acoustic studio

20 October 2017

**TARONGA ZOO CONSERVATION SOCIETY - AFRICAN SAVANNAH AND CONGO
EXHIBIT
RESPONSE TO SSDA SUBMISSIONS RELATING TO ACOUSTICS**

1 LION VIEWING & BOH SECTION/SOUTH ELEVATION

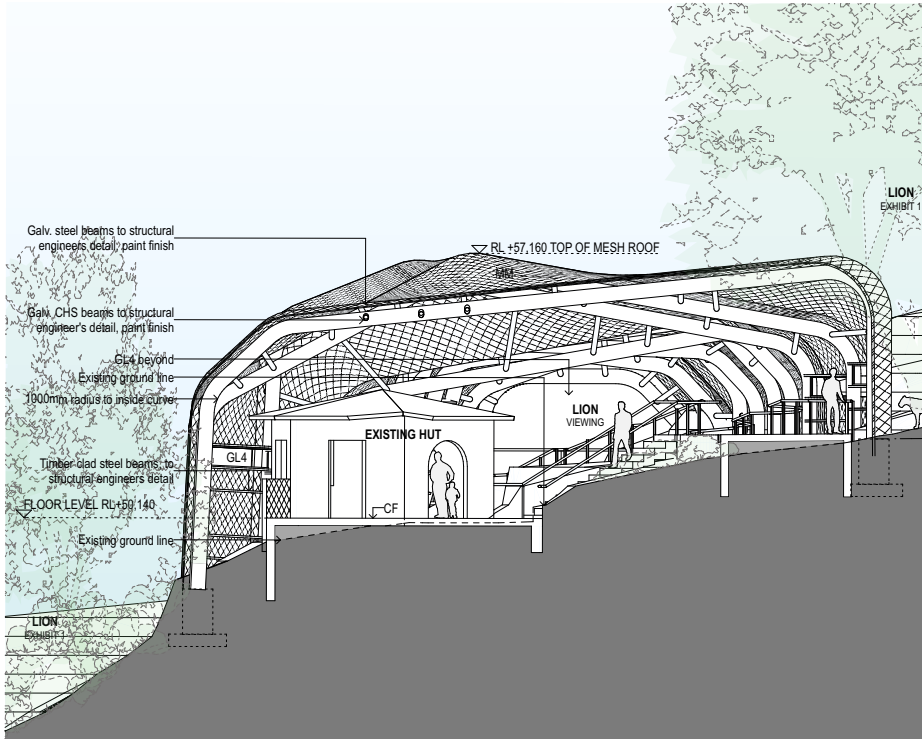
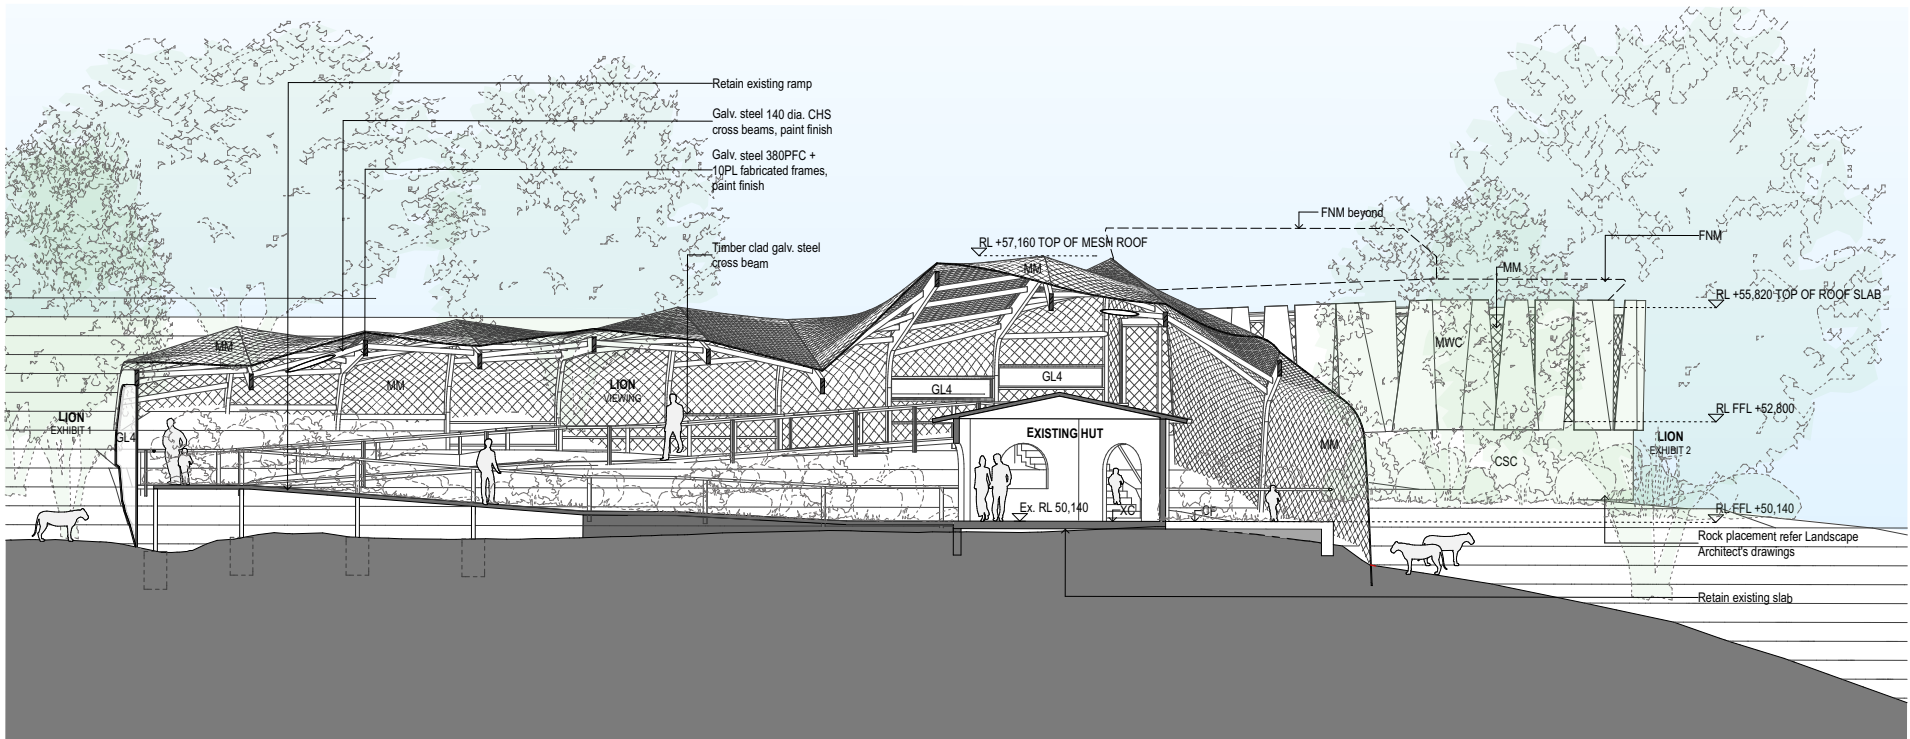
1. The NSW Department of Planning and Environment requests confirmation that the proposed development incorporated the methods outlined within the Acoustic Report section 6.3.4, to mitigate animal noise in outdoor areas during defined night time hours.

As noted above, at night lions are kept in their dens, rather than in outdoor areas, but they do have access to outdoor areas in case they are unwell, or escaping a position of conflict. If the lions roar when outside at night, it is likely to be a sign of an atypical situation requiring Zoo staff intervention, such as a disturbance among the animals.

The enclosure is to be constructed of blockwork with no doors or openings facing the north or west (in the direction of residential receivers). Upper level wall grilles will provide natural ventilation on the south-facing walls. Significant noise shielding between the openings in the dens and the nearest residential receivers is provided by the building itself, natural topography, and existing buildings on the Zoo premises.

Acoustic Studio has assessed the distance and shielding attenuation, and the likely attenuation through open mesh grilles from south-facing openings as well as from the

proposed Bondek type roof (with internal insulation). Predicted roaring noise levels from inside the den are approximately 56-61dB(A) at the nearest residential receiver, assuming the maximum noise level roar. This complies with the Sleep Awakening Level. This analysis assumes the maximum noise level roar, which is unusual for lions in captivity, and that they would roar at night inside the dens, which would be highly atypical behaviour. The more typical roaring noise level would be 46-51dB(A) at the nearest residence, which is below the Sleep Disturbance Screening Level.

Outdoor areas just outside the dens, which the lions may access at night, are well shielded from residential receivers by buildings such as the lion dens as well as other zoo buildings, and topography. Therefore solid fences would not provide any noise benefit. Where they are provided as part of the proposal, they do not perform an acoustic function. With the clarification that lions do have access to some outdoor areas at night, Acoustic Studio has predicted roaring noise levels from just outside the den. If the lions do venture outside and roar at maximum volume, the predicted noise level at the nearest residential receiver would be approximately 61-66dB(A). This generally complies with the Sleep Awakening Level (at worst, it would exceed the Sleep Awakening Level by 1dB). The level would be approximately 51-56dB(A) assuming the more typical roar noise level which was measured by Acoustic Studio at Perth Zoo. This is below the Sleep Awakening Level assuming residential windows facing the Zoo are open sufficiently to provide natural ventilation.
